WEST SUSSEX COUNTY COUNCIL CONSULTATION

TO:	Arun District Council FAO: Anita Gardner
FROM:	Highways, WSCC
DATE:	04/01/2019
LOCATION:	Gladwyn, The Street, East Preston, BN16 1HT
SUBJECT:	EP/179/18/PL Demolition of existing house & erection of 3x 3 bedroom houses together with landscaping, car parking and fencing.
DATE OF SITE VISIT:	N/A
RECOMMENDATION:	☒ Advice ☐ Objection ☐ Modification ☐ No Objection ☐ More Information ☐ Refusal
S106 CONTRIBUTION TOTAL:	£N/A

Project: Proposed new homes; Gladwyn, The Street, East Preston BN16 1HT			
Drawing: Block plan			
FOR: Mrs. J. Simmonds & Mr. P. Beamish			
Drawn: PKS	Date: November 2018		
Scales: 1:200	No: 2386/01/03/A		
To scale when printed on A3

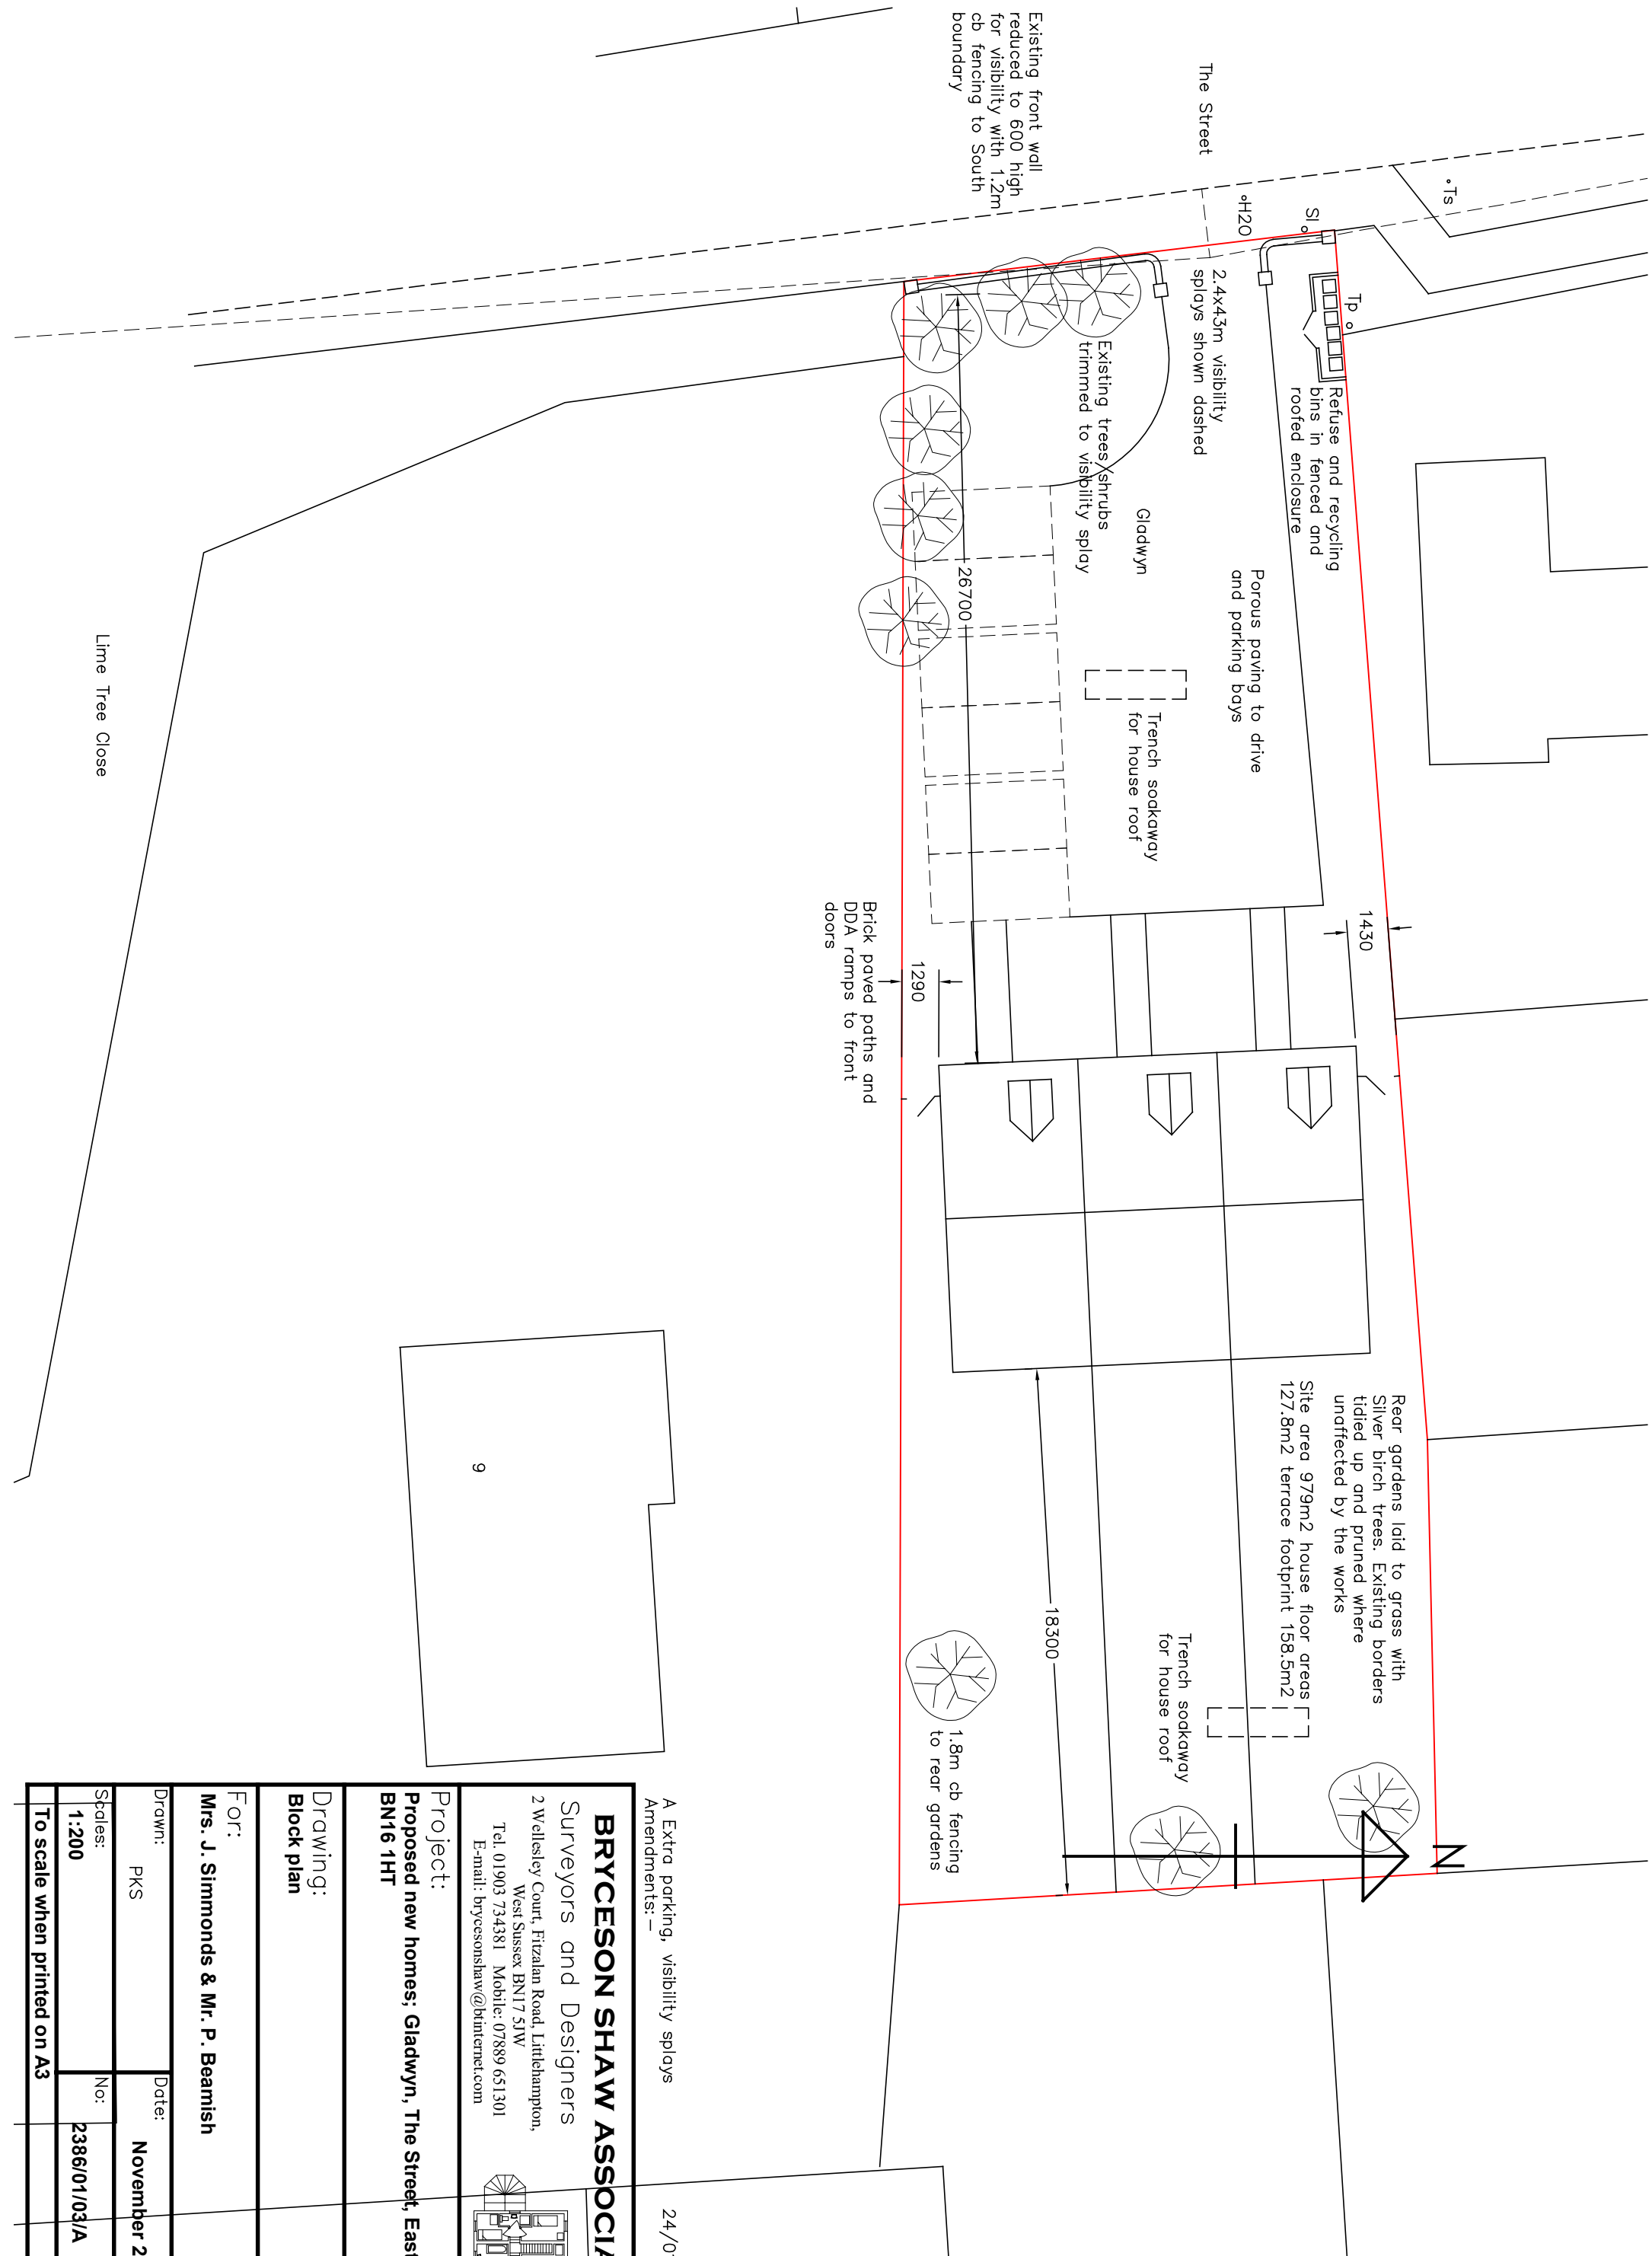
The proposed plans indicate that the existing 3.5m access will be utilised to serve the three proposed dwellings. The applicant may wish to consider widening the access to a minimum of 4.5m width to allow two vehicles to pass at slow speed. Any proposed access works would be subject to approval by the Local Highway Authority and subject to a licence from the Local Area Engineer.

Visibility at the existing access has not been demonstrated. As the proposal would result in an intensification of use at the existing access, visibility splays should be provided, demonstrating safe and suitable access onto The Street. Details of visibility can be secured via condition – the applicant should be aware that this is likely to impact upon the existing boundary wall. As The Street is subject to 30mph, Manual for Streets (MfS) is the appropriate standard for this location. This sets out a minimum stopping sight distance (SSD) of 43m in each direction at 2.4m from the back edge of the carriageway. The splays must intersect land only within the control of the applicant, or within the publically maintained highway and be drawn to the *nearside edge* of the carriageway in *both* directions.

The proposed plans indicate that a total of four parking spaces will be provided for the three dwellings. The WSCC Car parking demand calculator anticipates that this is a sufficient parking provision if spaces remain unallocated. If spaces are to be allocated at 1 per dwelling, a minimum of 5 parking spaces will be required to allow for visitor parking. If the applicant intends to allocate parking spaces, there appears to be sufficient space on site to accommodate a fifth parking space. Each space meets minimum specifications of 2.4 x 4.8m as set out in Manual for Streets (MfS). There appears to be

sufficient space on site for vehicles to turn and exit onto the publically maintained highway in a forward gear.

No part of the development shall be first occupied until visibility splays of 2.4 metres by 43 metres have been provided at the proposed site vehicular access onto The Street in accordance with plans and details to be submitted to and approved in writing by the Local Planning Authority. Once provided the splays shall thereafter be maintained and kept free of all obstructions over a height of 0.6 metre above adjoining carriageway level or as otherwise agreed.

No part of the development shall be first occupied until the car parking has been constructed in accordance with the approved site plan. These spaces shall thereafter be retained at all times for their designated purpose.
